Council Reference: DA20/0478.01 LN6167
Your Reference: SSD-8378620-Mod-1

Development Application SSD-8378620-Mod-1 (Council reference DA20/0478.01) - amendment to Development Consent DA20/0478 (SSD-8378620) for Kingscliff Public School redevelopment (SSD-8378620 - Mod-1) at Lot 1 DP 384195; No. 12 Orient Street KINGSCLIFF

Council officers have undertaken a review of the Mod 1 documentation and provide the following comments for the Department's consideration.

DRAWING TITLE
Landscape Plan 01

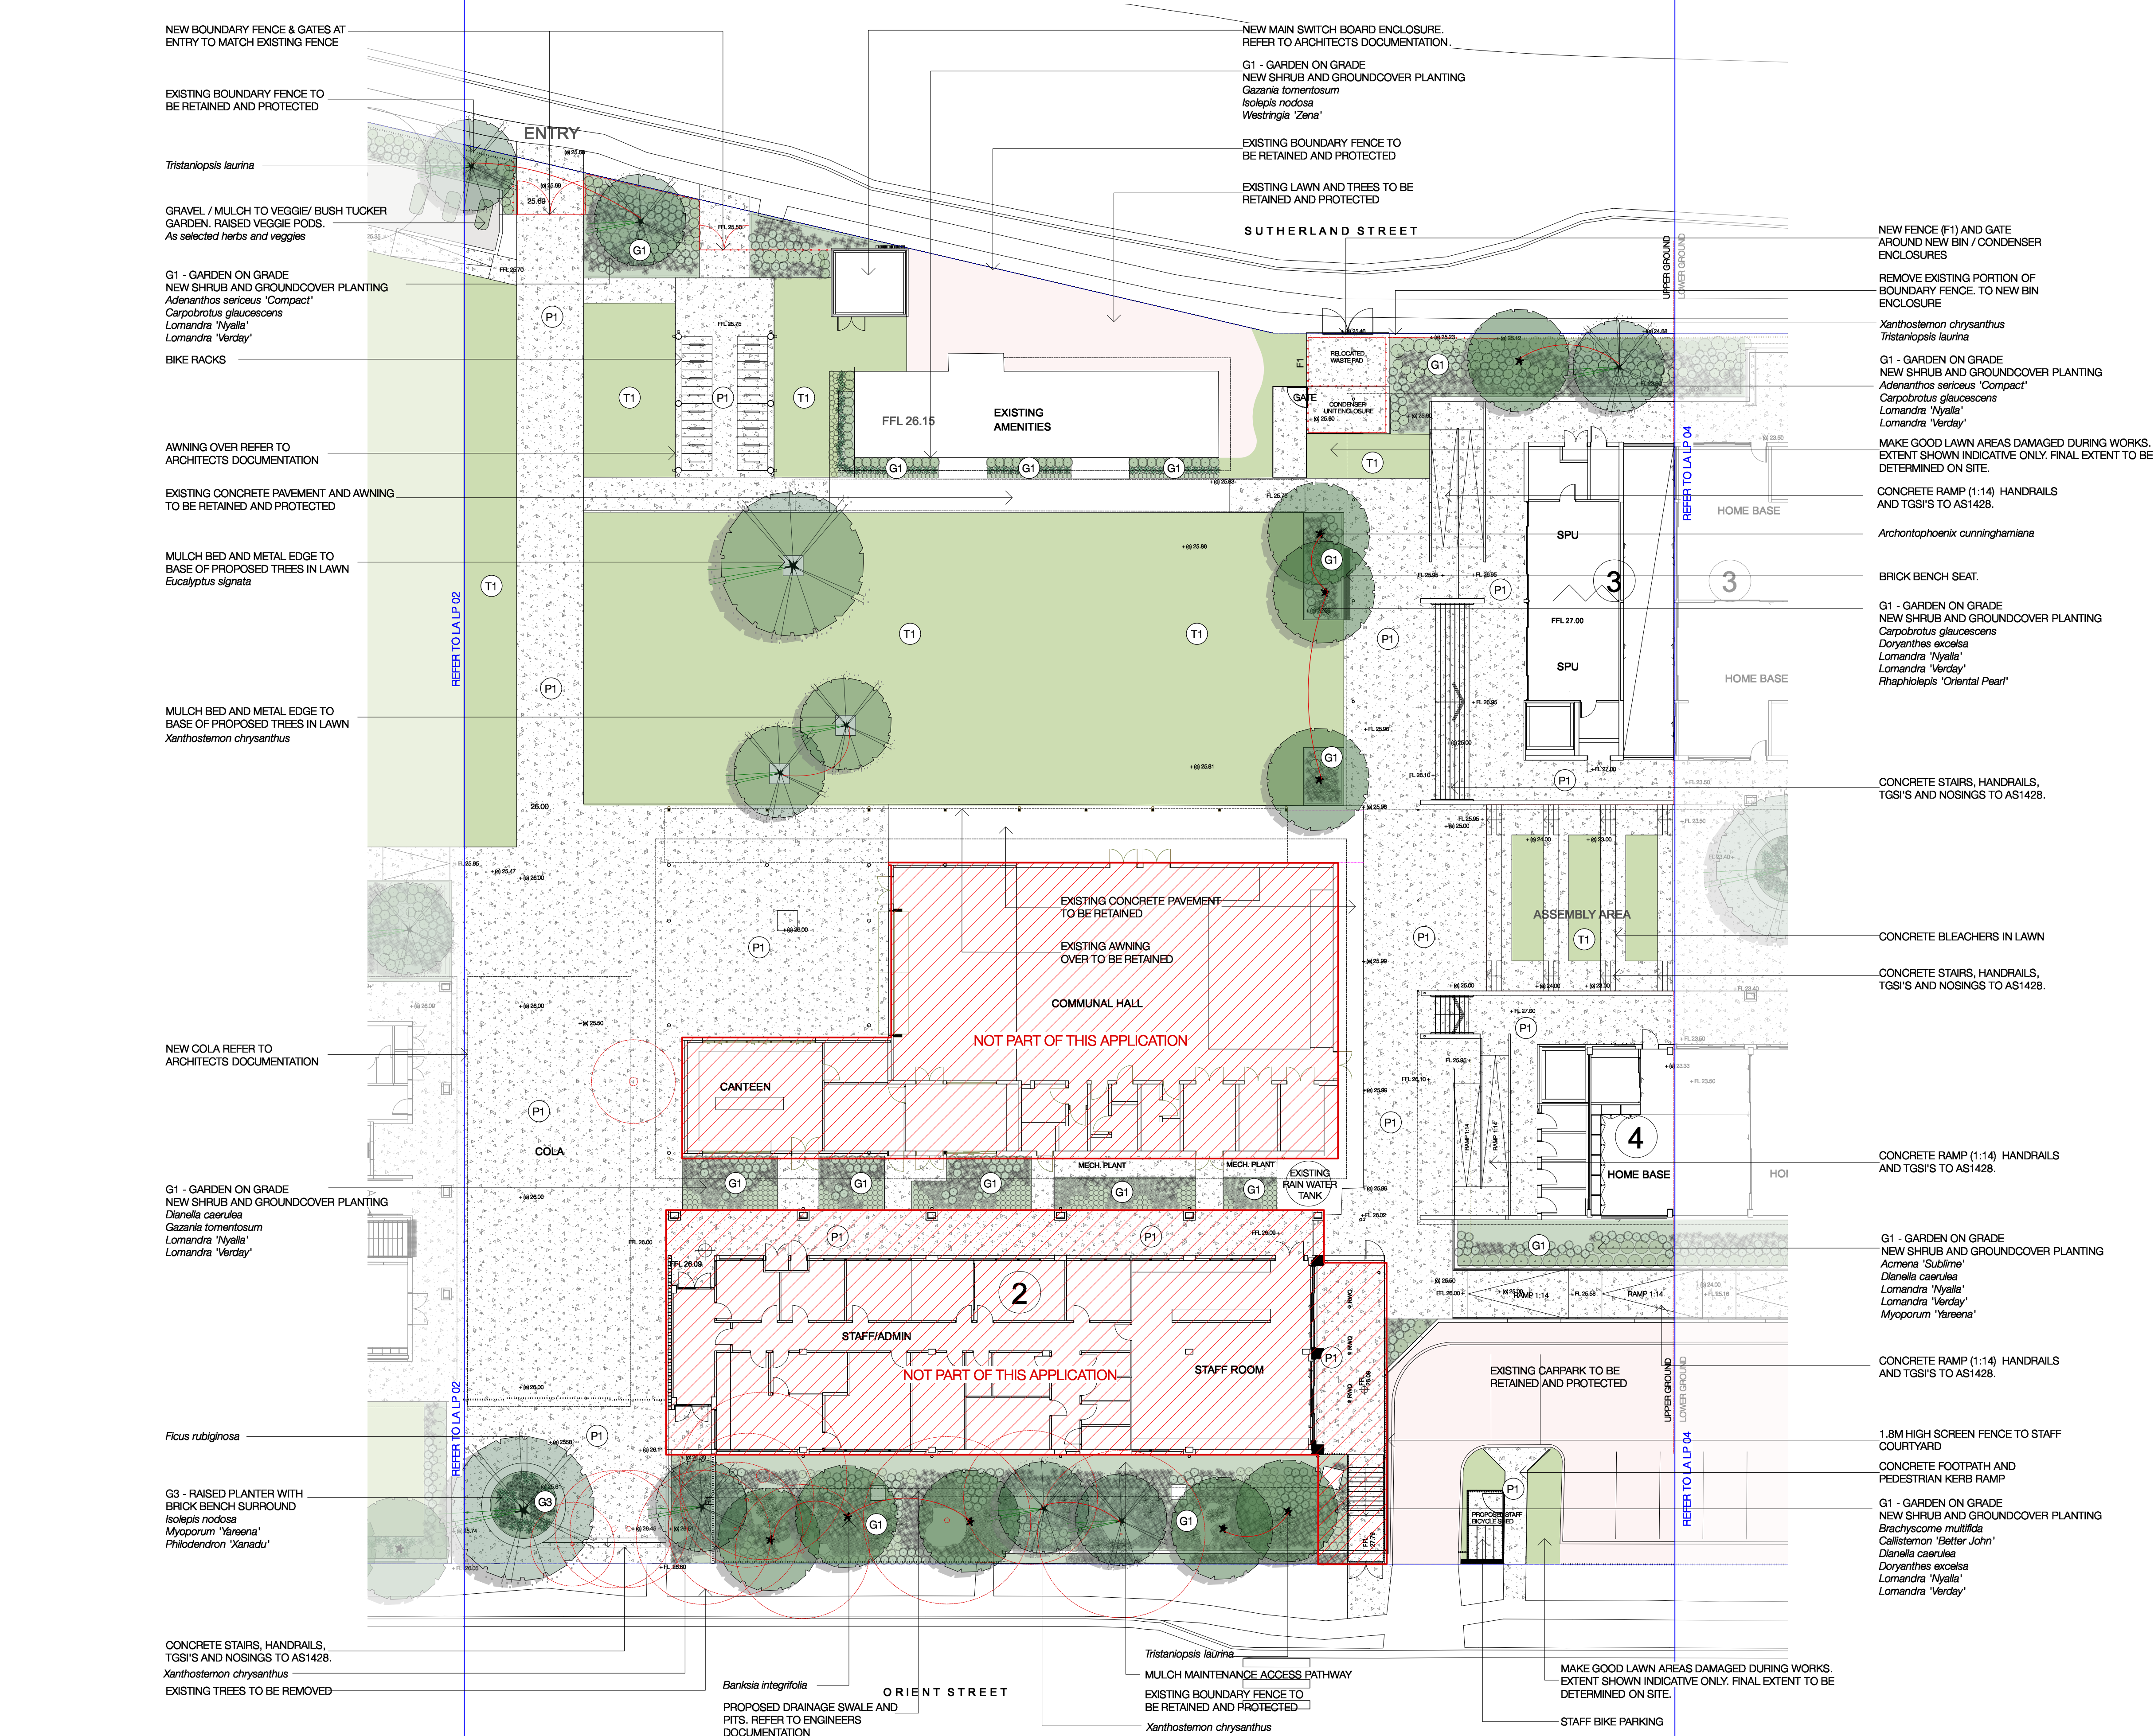
No objection is raised in terms of the proposed replacement of 2 x Port Jackson Figs (*Ficus rubiginosa*) with 2 x Lemon Myrtle feature trees (*Backhousia citrifolia*).
